### The Able Marine Energy Park (Amendment) Order 201[ ]

An application has been made under paragraph 2 of Schedule 6 to the Planning Act 2008(a) to the Secretary of State in accordance with the Infrastructure Planning (Changes to, and Revocation of, Development Consent Orders) Regulations 2011(b) for a non-material change to The Able Marine Energy Park Development Consent Order 2014(c).

This Order follows an application under paragraph 2 of the Schedule 6 to the Act for a non-material change to allow an alteration to the location of the mitigation sites provided for in the 2014 Order.

Drawing file: published-documents / TR030001-003455-Able NMC - Tab 3(1) - Substitute Plan - AME - 02006 C Indicative Masterplan.pdf

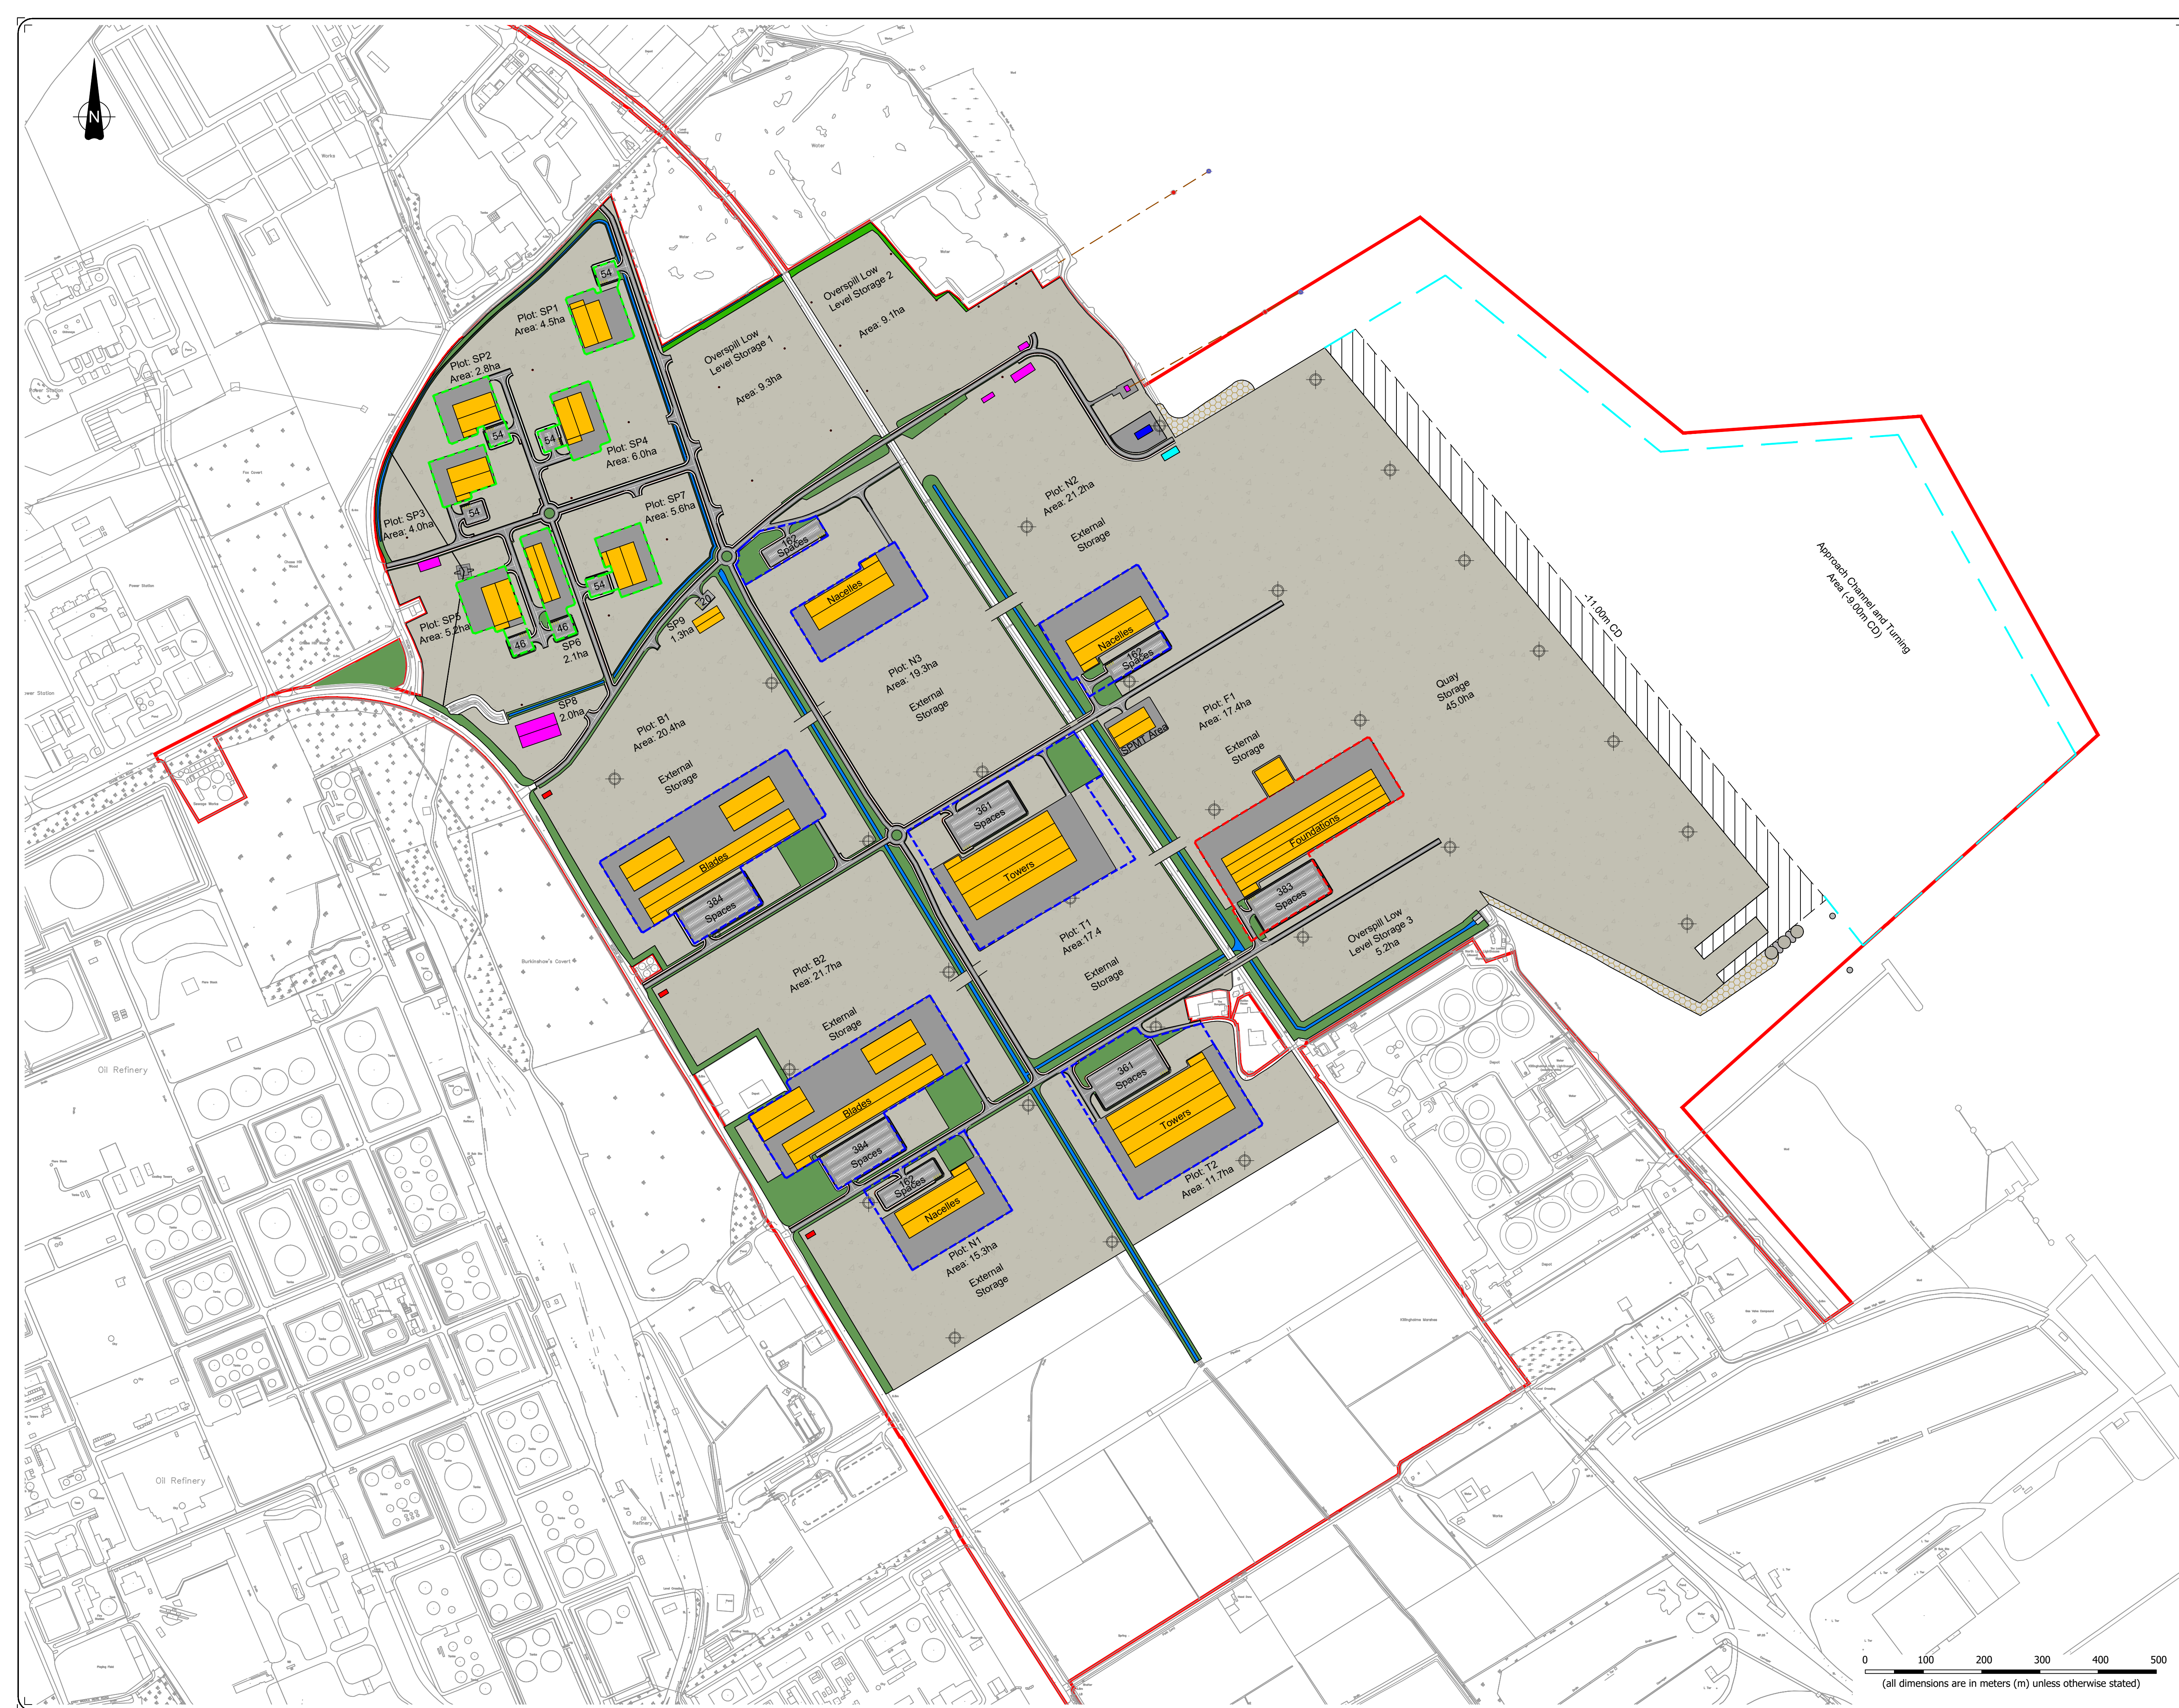
- (a) in subparagraph (i) for “AME–02006” substitute “AME–02006 (Rev C)”;
